From: Michael Eastham <Michael.Eastham@arun.gov.uk>
Sent: 09 December 2020 21:07
To: Planning.Responses <Planning.Responses@arun.gov.uk>
Subject: FW: Emergency Access (for fire and rescue, police and ambulance service), Weavers Hill, Angmering - reserved matters application A/109/20/RES

Please upload onto Ocella the email below which is a consultation response from the **WSSC Fire and Rescue Service** to reserved matters application **A/109/20/RES** relating to Land South of Water Lane, Angmering.

The proposed layout plan for the reserved matters application **A/109/20/RES** for 175 houses on Land South of Water Lane, in Angmering does not include an emergency access (for fire and rescue, police and ambulance service) off Weavers Hill. The provision of an emergency access in this location was part of the approved parameters plans at the outline planning stage (**A/99/17/OUT**).

Appendix B - Site Access Drawing

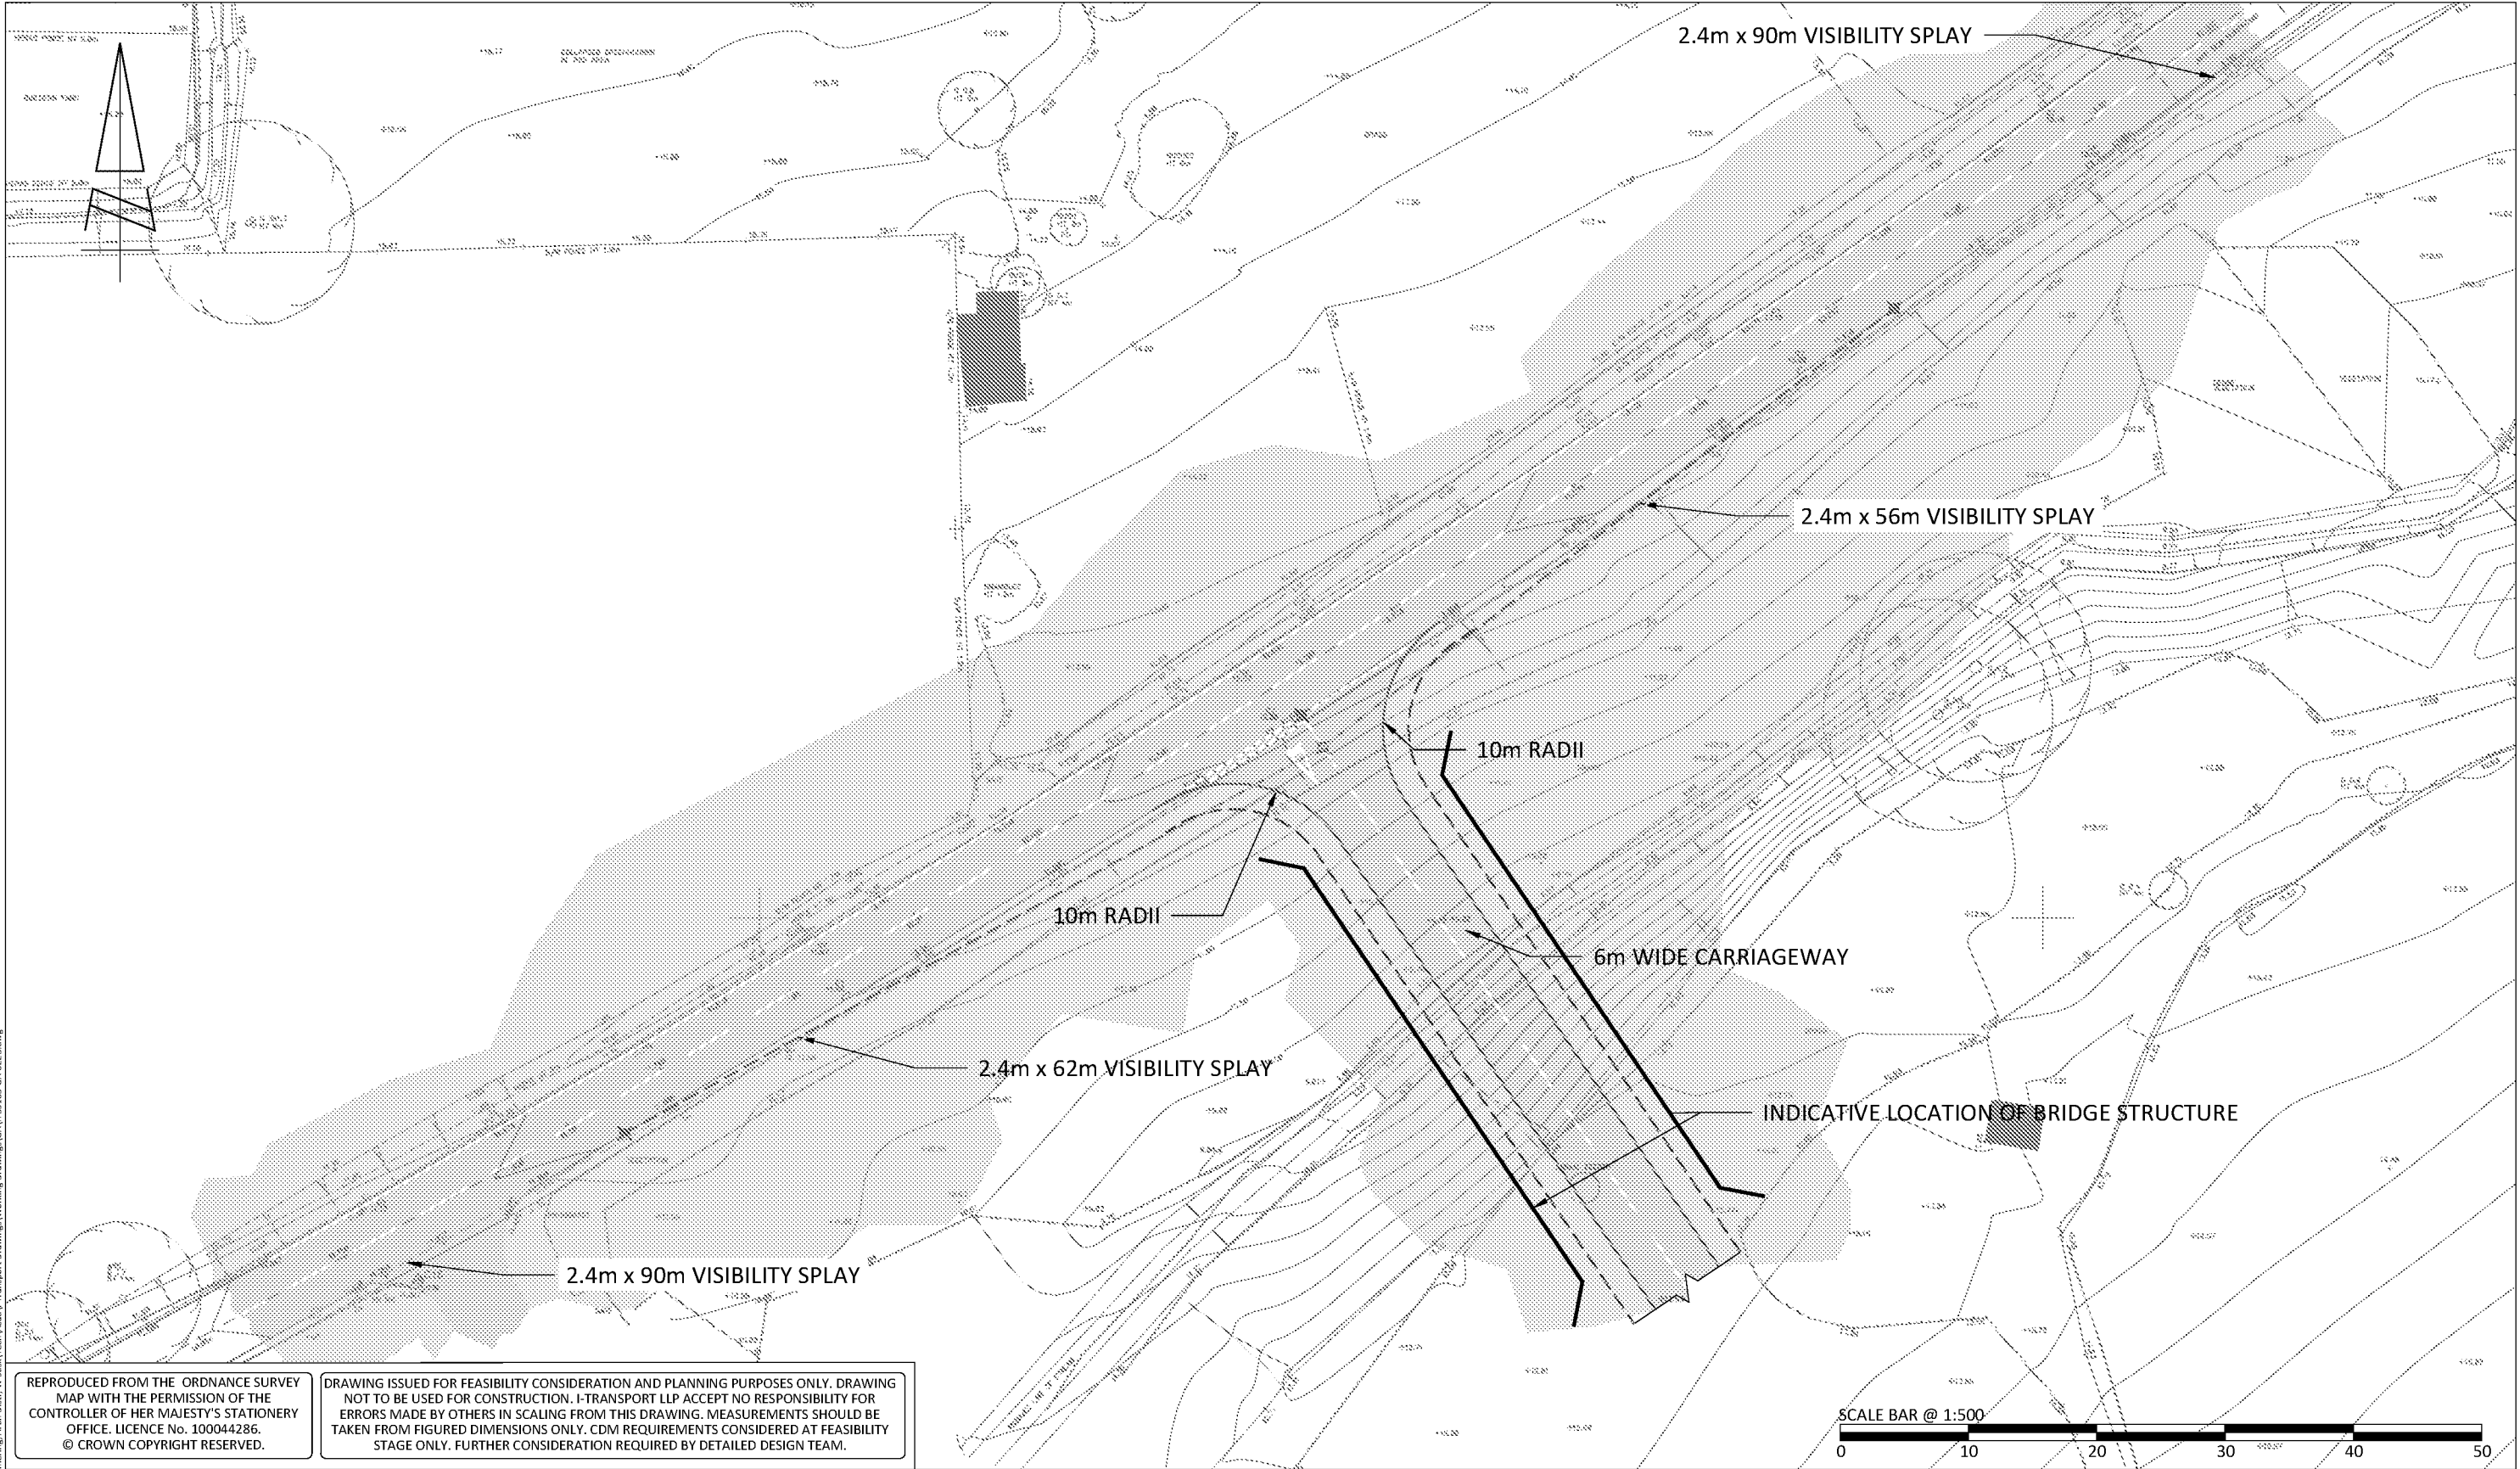
Having viewed the plans for the site again, I think providing we have the main access route from the Weavers Croft end and emergency access the opposite end by the Spotted Cow PH (although this access route is unclear, is it emergency use only?) would be sufficient for the number of houses on the site. Clearly an additional access point from weavers Hill would give us better, quicker access to the section of houses by Weaver Hill and an alternative route out if a large incident were to occur.

Without a through road onto Weaver Hill this section of housing affectively has a dead-end access route for the Fire Service, so it will be important to ensure that any turning head for a Fire Appliance meets with the requirements of Approved Document – B Volume 1 2019 edition section 13 and equally important they are kept clear of vehicles at all times; as we know from experience these turning heads soon become filled with parked cars leaving no space for a Fire Appliance to turn and make their exit.

So although I do not think we could insist on this access route it would certainly be beneficial to the Fire Service, saving time attending a fire and an easier route out should more than one fire appliance be in attendance.
